Engineers Comments Regarding Proposed Surface Water Drainage Design

APPLICATION NO: BR/327/19/DOC

Site Address: 283-285A Chichester Road Bognor Regis PO21 5AH

Description of Works: Approval of details reserved by condition imposed under ref BR/324/17/PL relating to Condition No 3 - surface water drainage, Pre-commencement site meeting with Tree Officer, 5 - Construction Management Plan, 6 - existing public sewer and 7 - foul sewerage disposal.

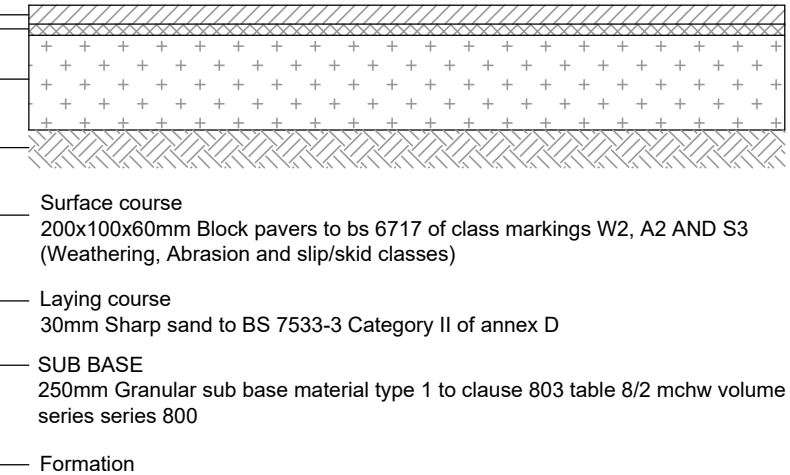
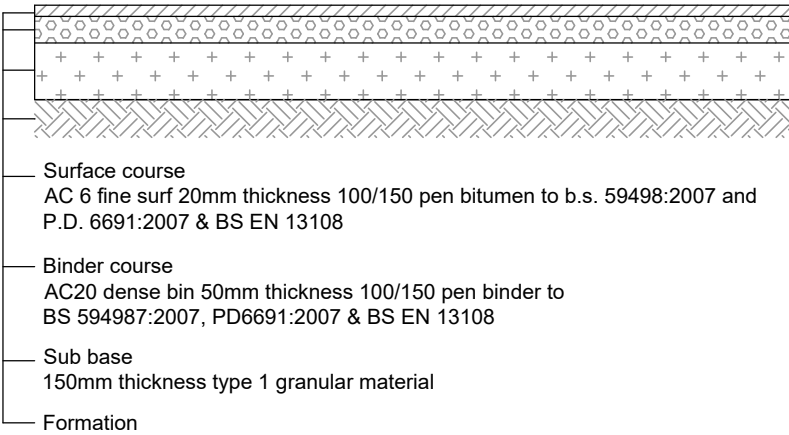
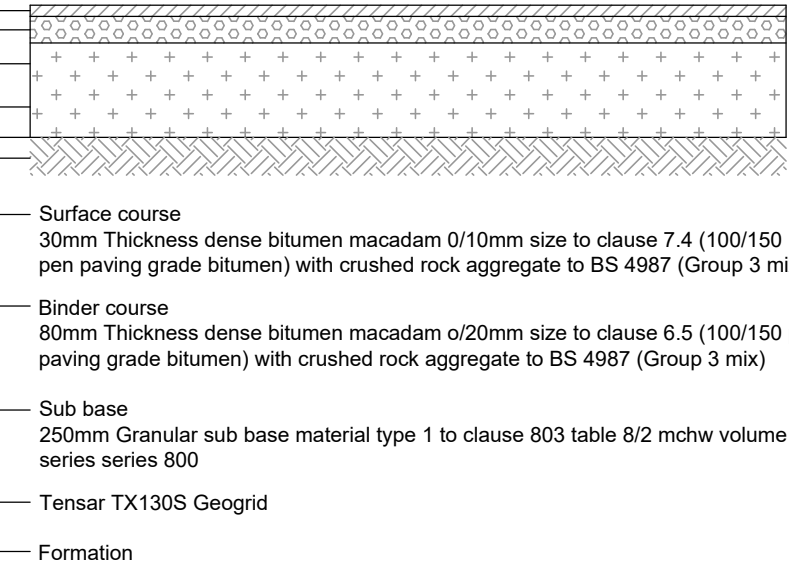
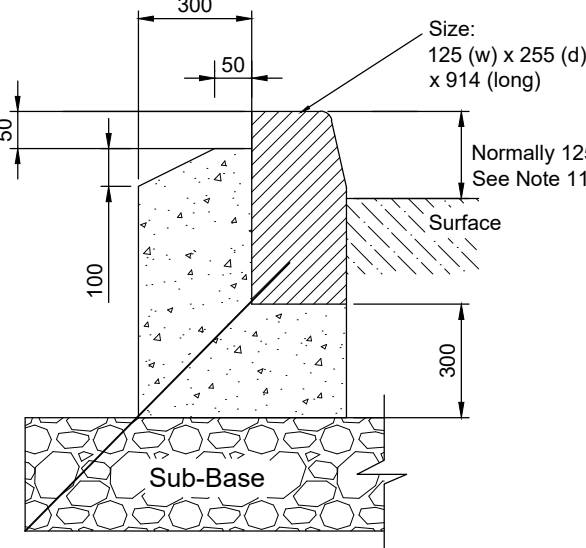
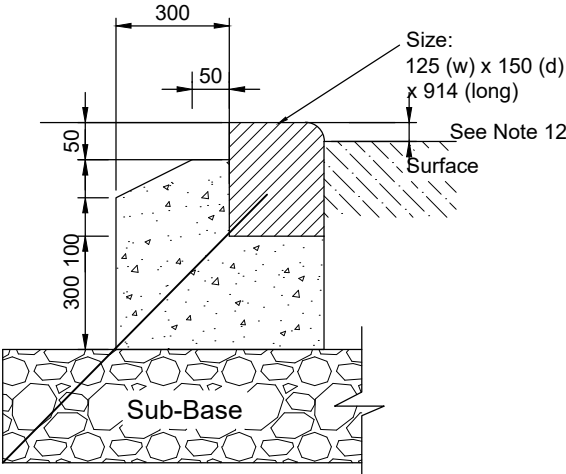
16: Pipe bedding – concrete bed and surround required where less than 1.2m cover in vehicular areas. Amend details and provide detail of expansion joints that are required where pipes receive concrete protection.
